Date: 6th May 2022

Our Ref: BN/54/22/WS

Non material amendment following WSCC/052/20 (BN/126/20/WS) to change location of westbound bus stop and shelter located on Southern Carriageway of the proposed scheme. Land to the north of Eastergate and north west of Barnham Barnham

Figure 2 – Bus stop relocation (source A29-CAP-HPN-00-DR-C-0133 S0-P14)

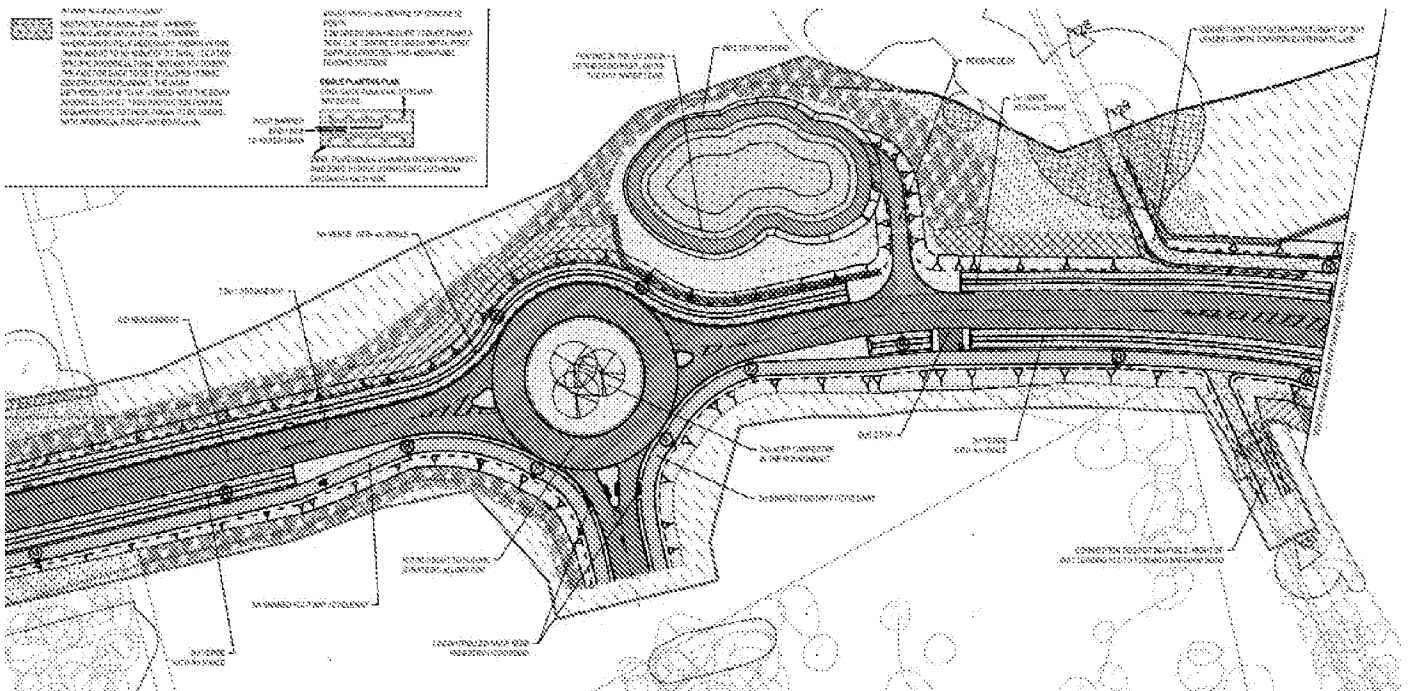
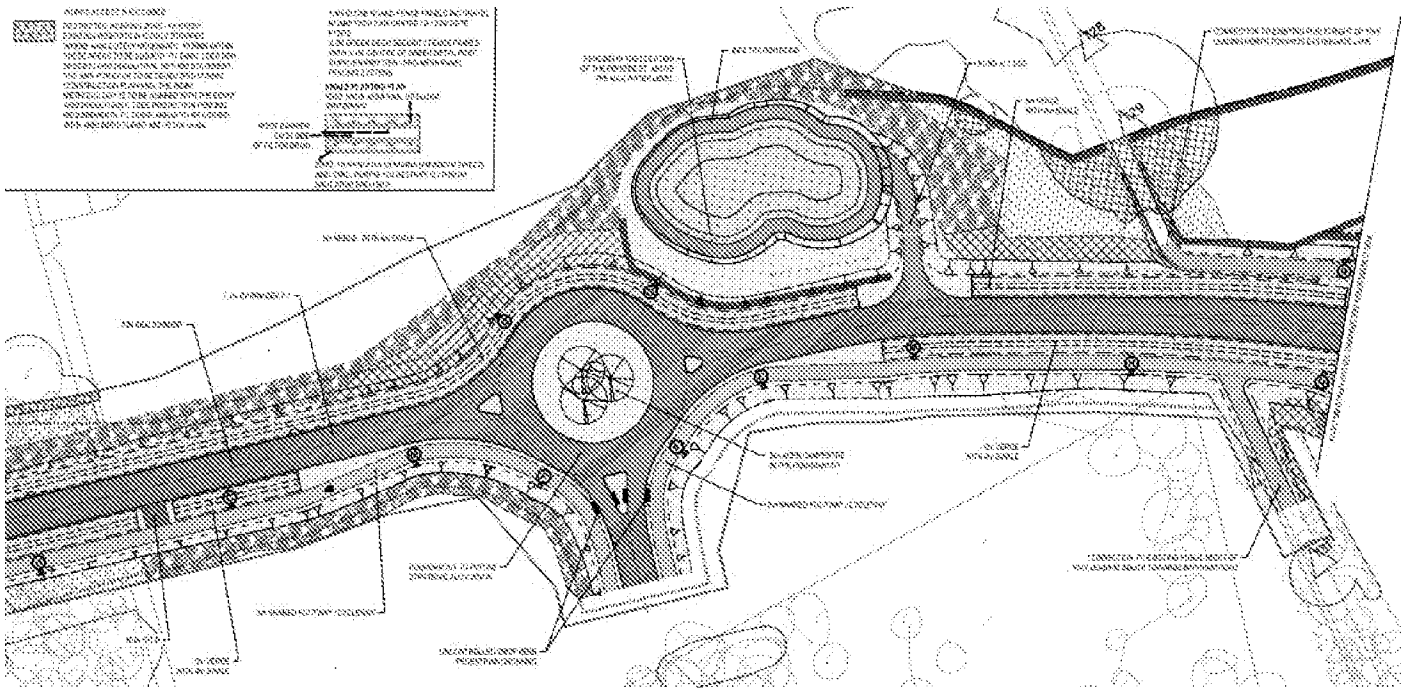
The proposed Non Material Amendment would result in the alteration of the position of the bus stop on the Southern Carriageway of the re-aligned A29. The re-positioned bus stop to the west of the roundabout would still ensure that it is accessible to the proposed development parcel to the south of the new A29 (part of the BEW Masterplanned area) and we would therefore not have any objection to its relocation.
